**KIRKLEES METROPOLITAN COUNCIL
INVESTMENT & REGENERATION SERVICE**

**DELEGATED DECISION TO DETERMINE APPLICATIONS FOR
NON-MATERIAL AMENDMENTS**

Reference No: 2021/NM/93851/W

Site Address: 68, Newsome Road, Newsome, Huddersfield, HD4 6NQ

Client		Mr & Mrs Smith	
Job		68 Newsome Road Newsome	
Title		Proposed Rear Elevation	
Drawn By	RK	Date	Jan 2021
Eng. Check		Scale	1:50
Tech. Check			
Drawing No.		Rev.	
2021 / 272 / 02

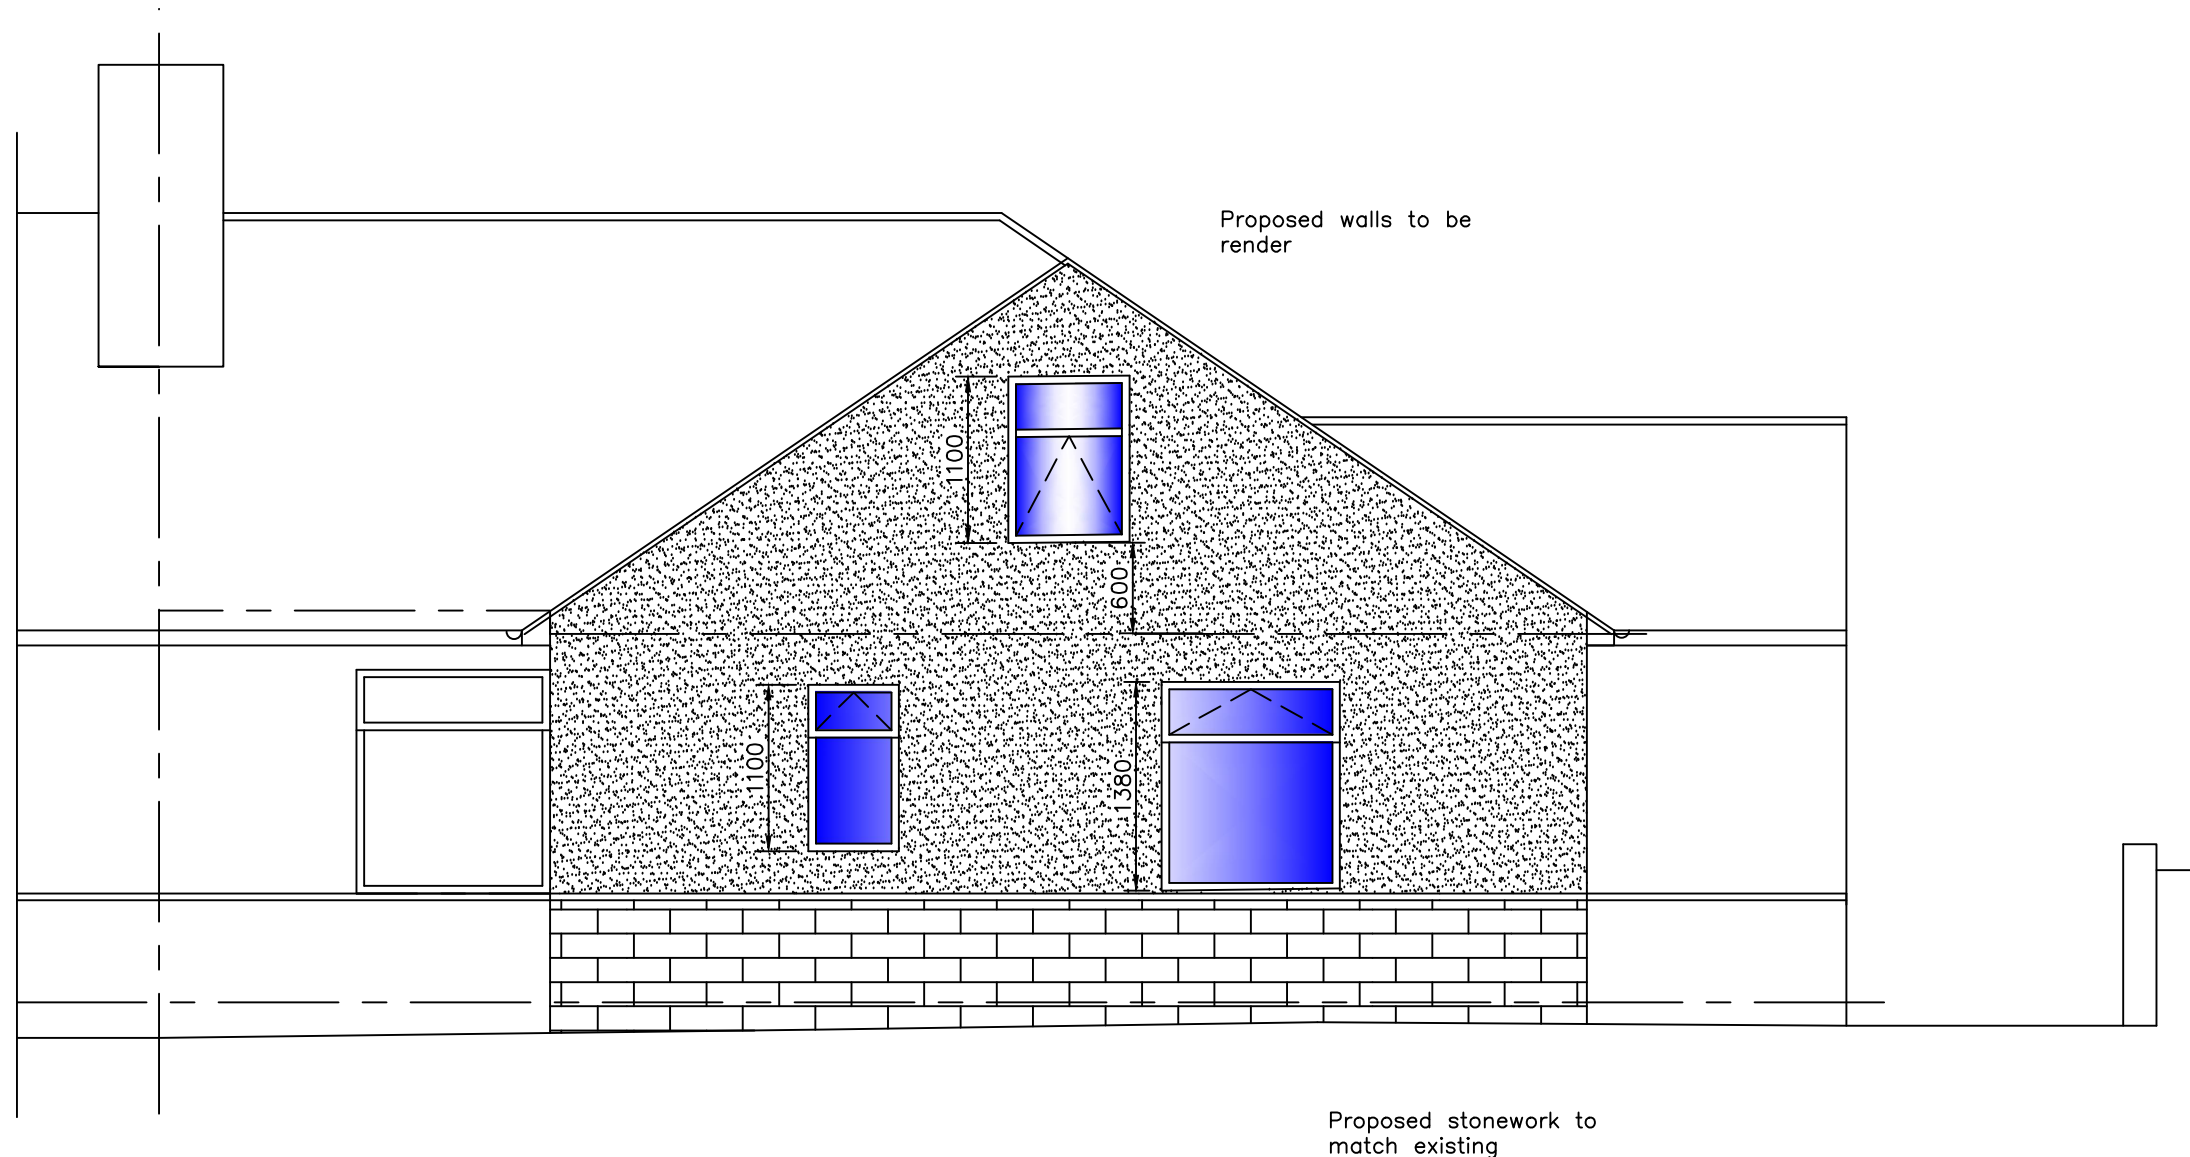
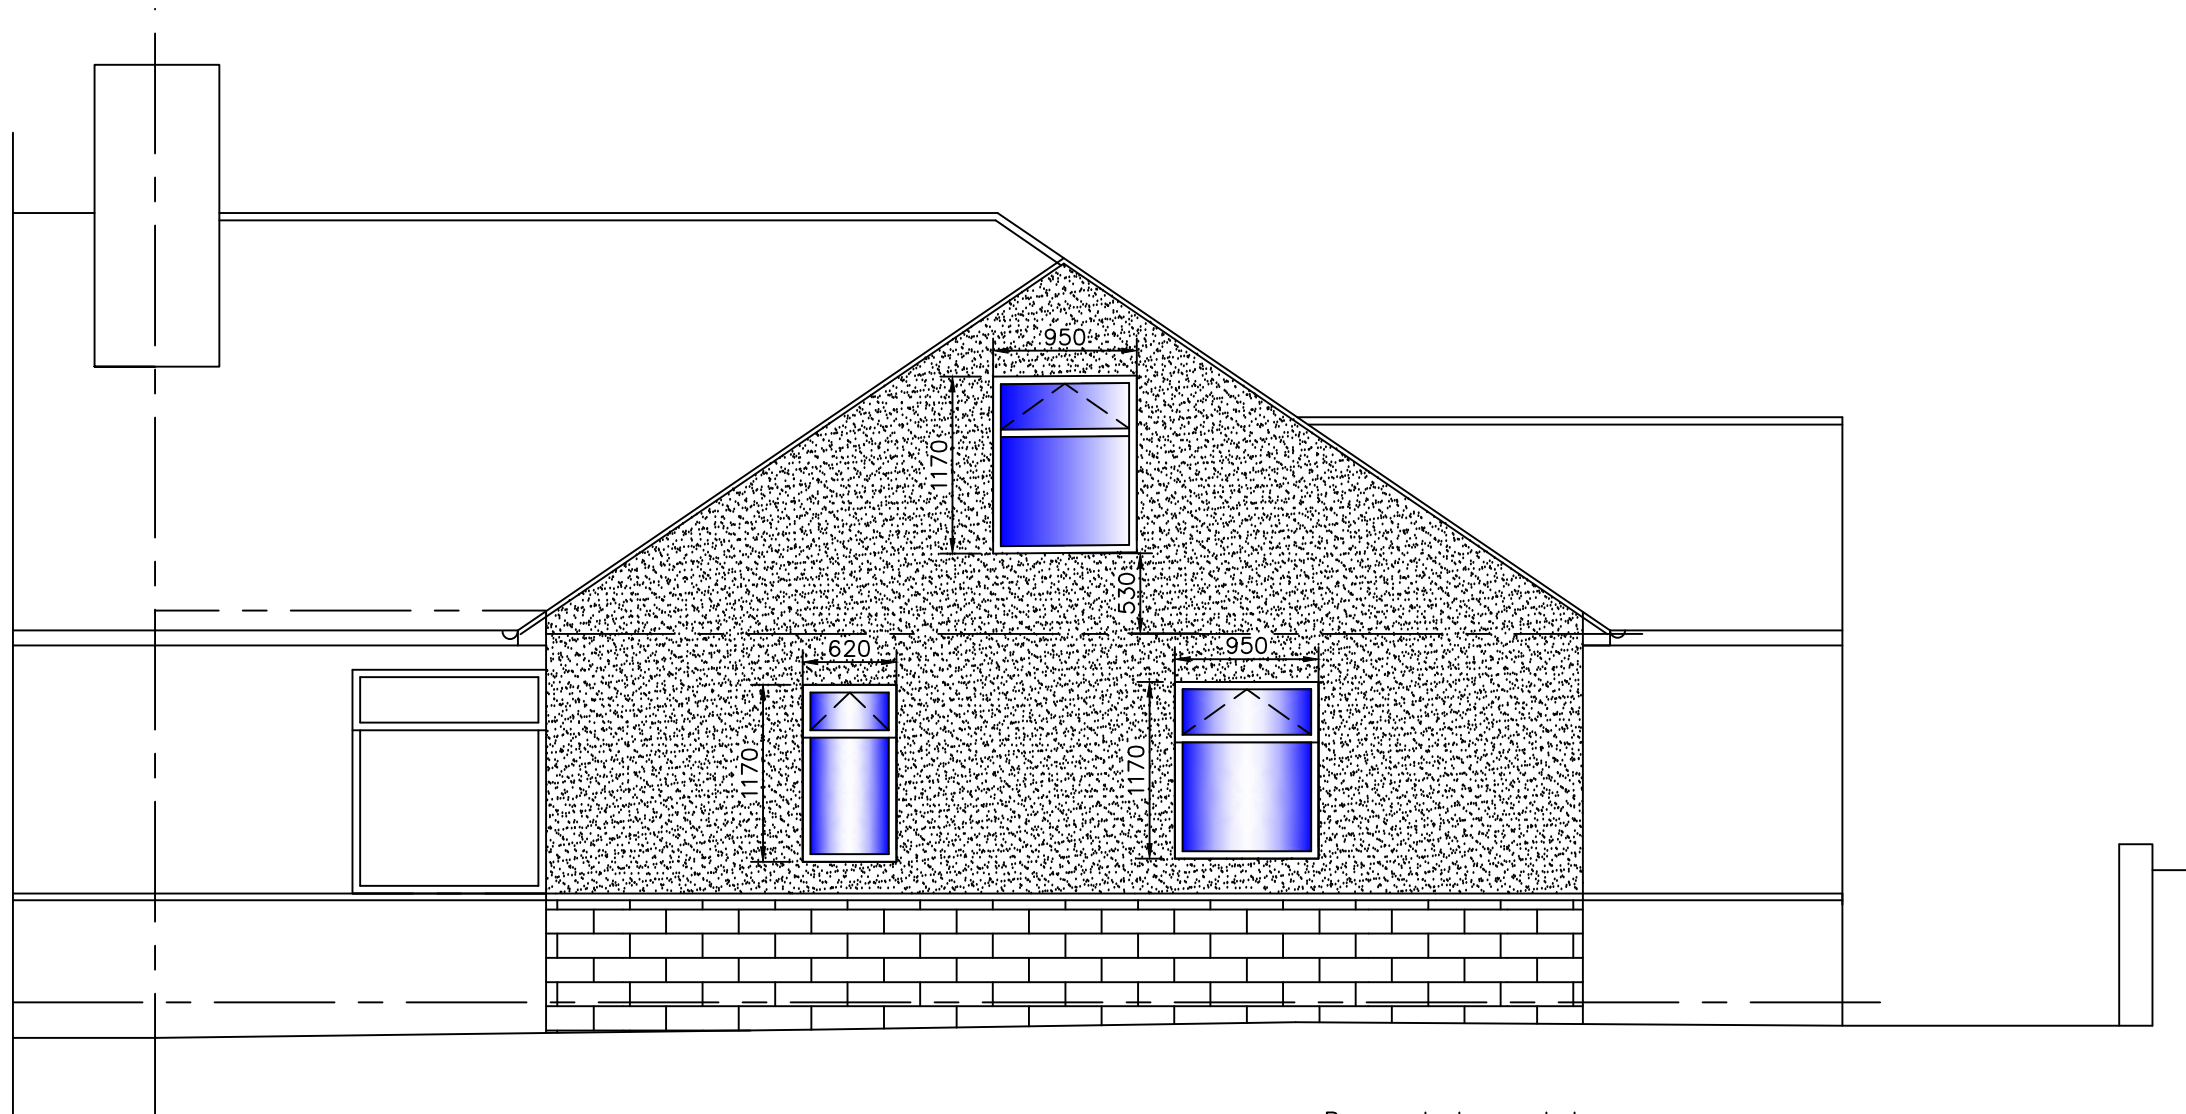
The amendment relates specifically to the rear elevation openings. The application was approved with 2 no. ground floor openings of different dimensions with the smaller being a height of 1100mm and the larger being a height of 1380mm. The upper floor window would also be a height of 1100mm.

It is proposed to alter all three openings within the rear elevation to be a total height of 1170mm in height due to practicality. 1 no. opening at ground floor and the upper floor window would be a width of 950mm with the other ground floor opening being a width of 620mm.

The amendment sought is to alter the heights of the proposed 3 no. openings to 1170mm as shown on drawing number 2021/272/02 received by the Local Planning Authority on 18th October 2021.
